**ADC Planning Consultation
Response from the Historic Buildings Adviser**

Application Number	AB/92/12/L
Address	33 Mount Pleasant, Arundel
Description	First and second floor extension and rear rooflights (amendments to AB/60/11/L).
Case Officer	Peter Cleveland
Site Visit	31 August 2012

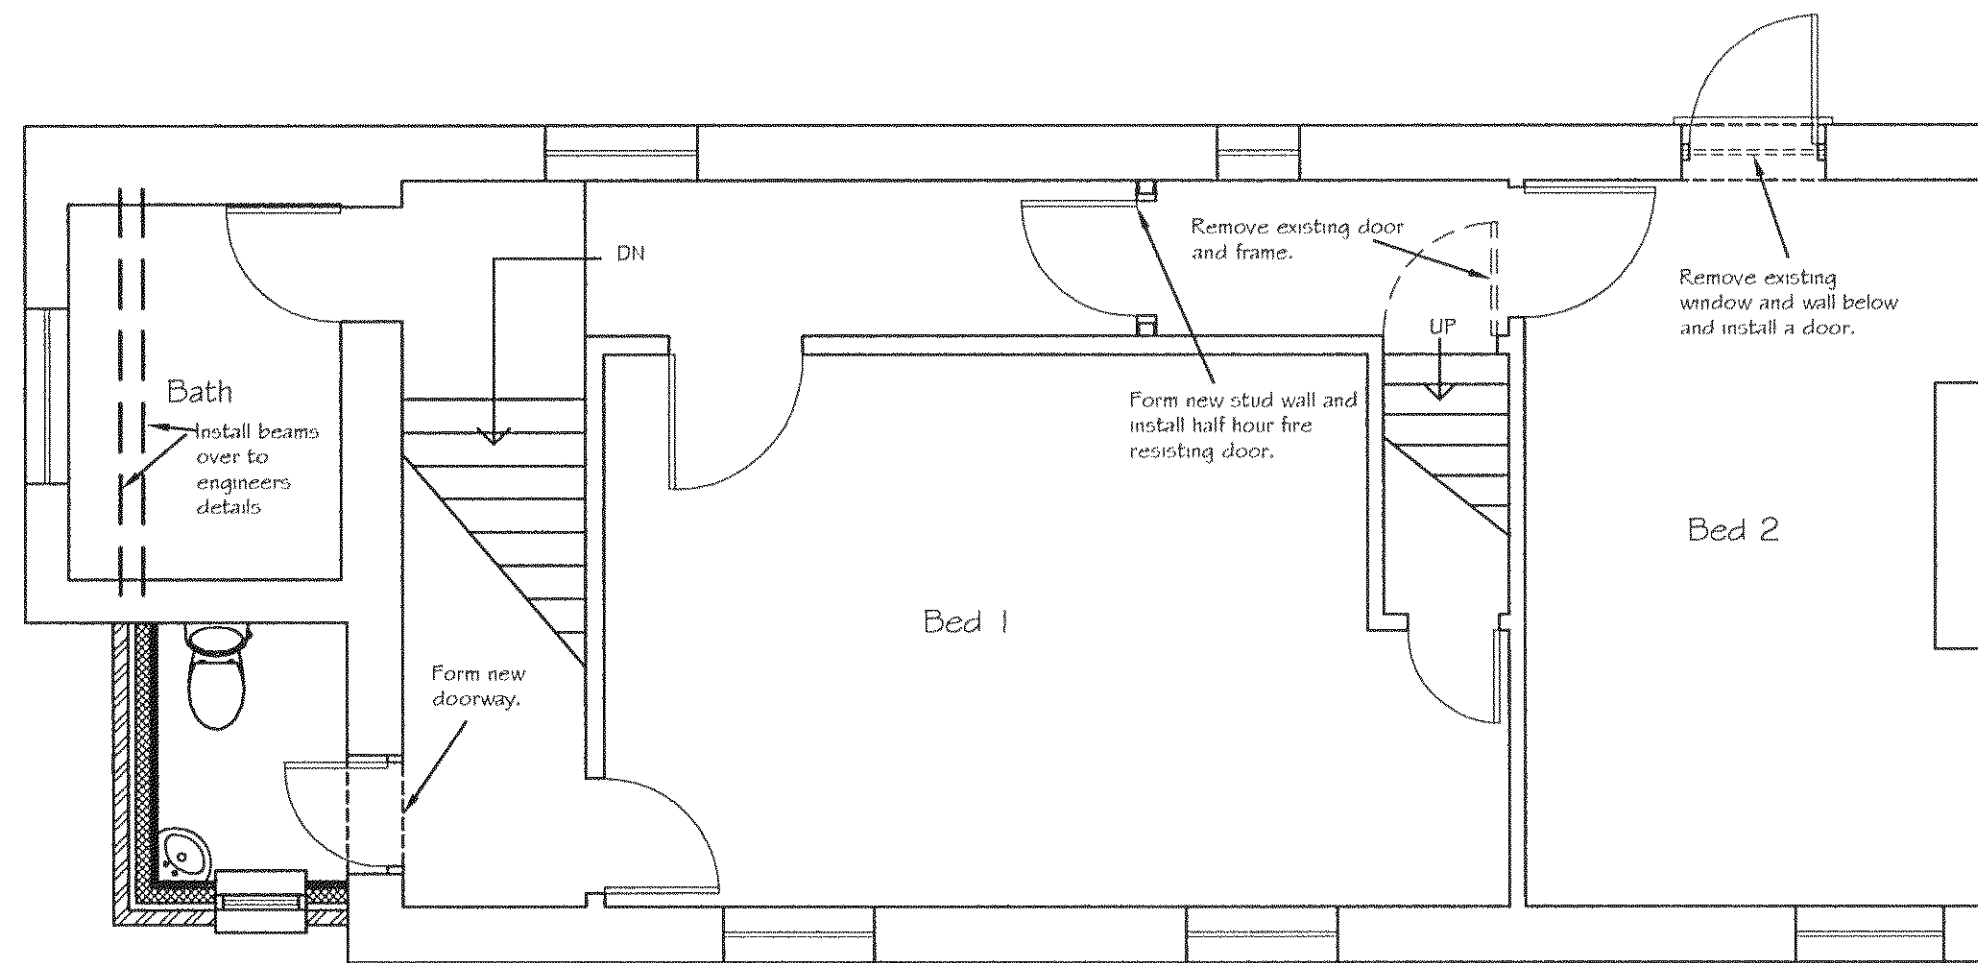
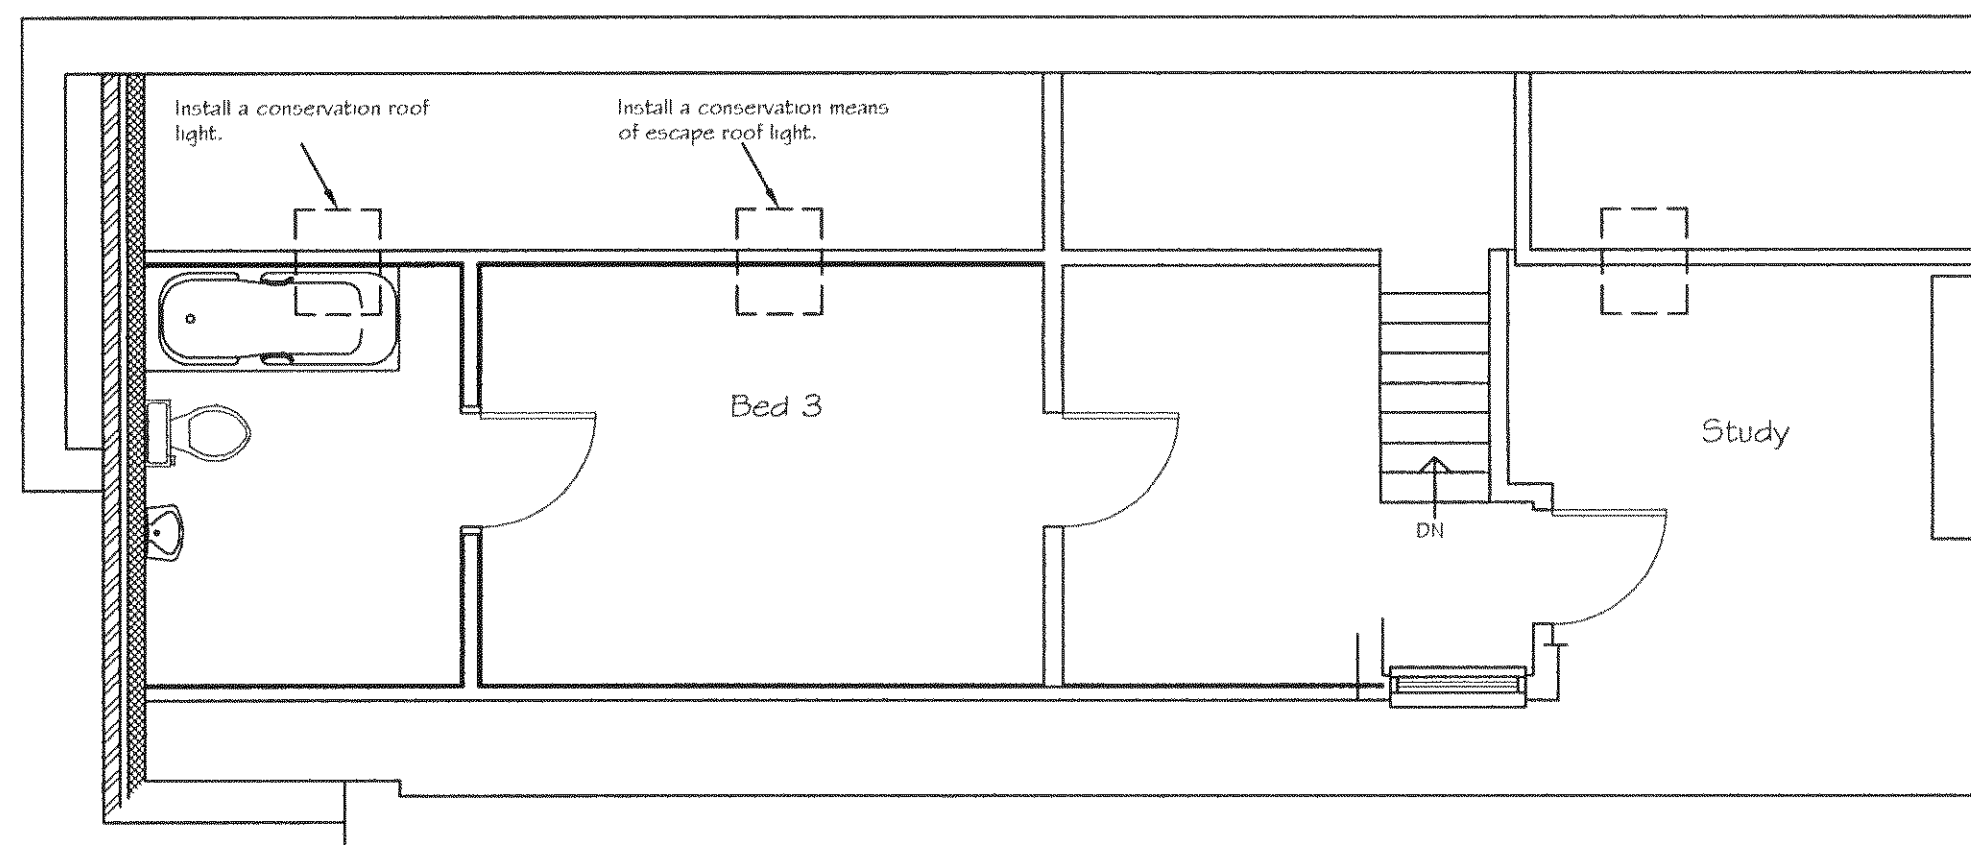
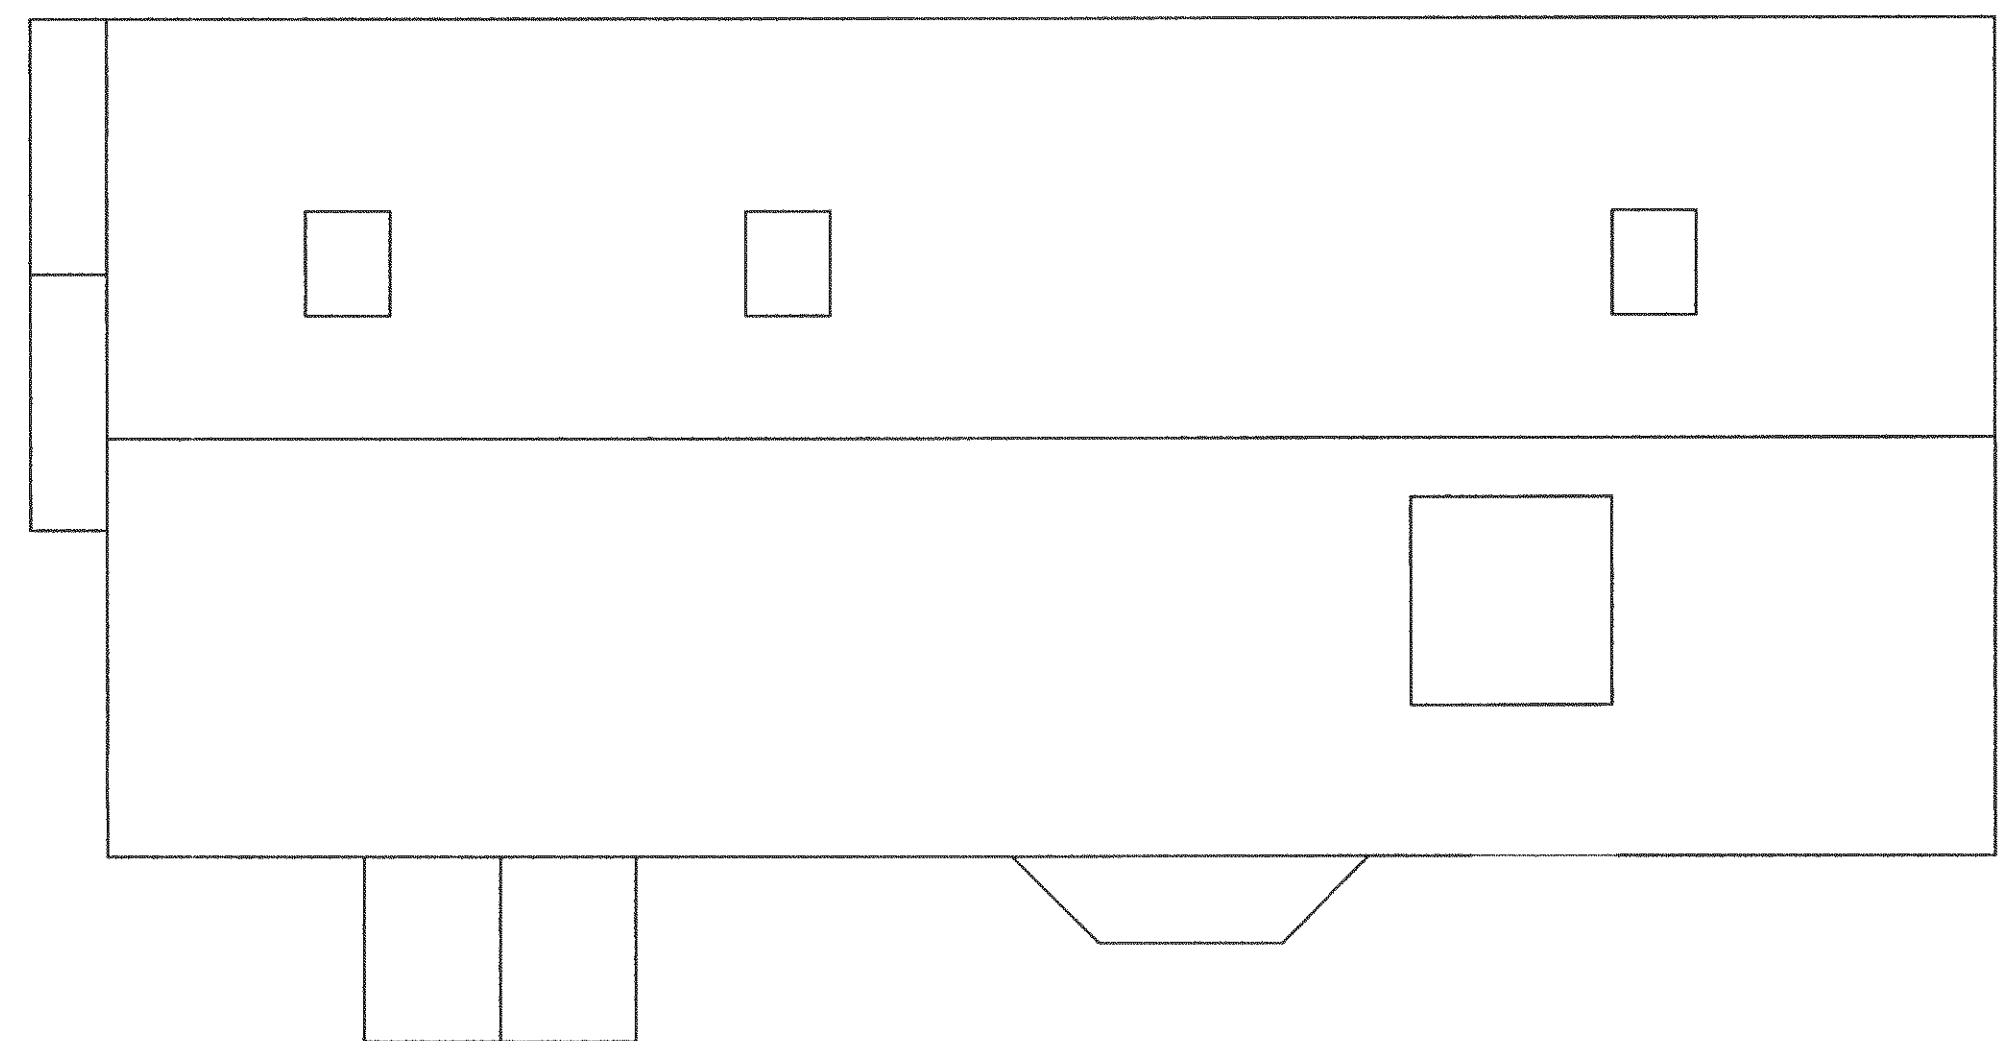
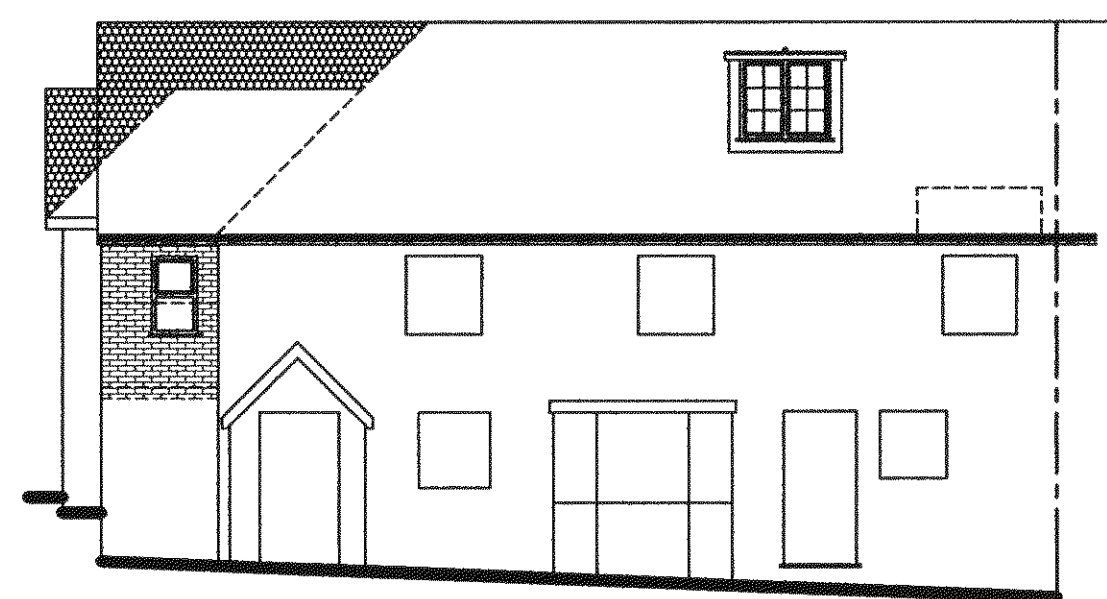
The proposed addition to this, of a two storey element to the north is extremely problematic, not least because it harms the appreciation and understanding of the listed building's historic form and scale. The continuation of the ridge line at the existing height is never normally acceptable for this reason as it alters the character of the building, as does the change from a hipped roof to a gable. This is contrary to English Heritage practice guidance for PPS5 (still relevant to the NPPF), which states:

In this instance the continuation of the roof form adds substantially to the building's massing at the north and in its elevated position will appear more imposing than it might otherwise. The addition also results in impacts such as the total loss of the north elevation and its cornice. A further concern here is the remnant of the earlier addition which is left to protrude slightly on the north elevation. The shallowness of this element is rather incongruous to the listed building and not appropriate. Another more minor issue is the first floor bathroom window which becomes part of the main fenestration and on plan at least appears largely unsympathetic.

Here, the scheme results in the formation of a bathroom on the second floor and a toilet on the first floor. This seems generous given the impact of the extension on the heritage asset and the resulting change in character. For this reason and those above I am afraid the scheme cannot be supported.
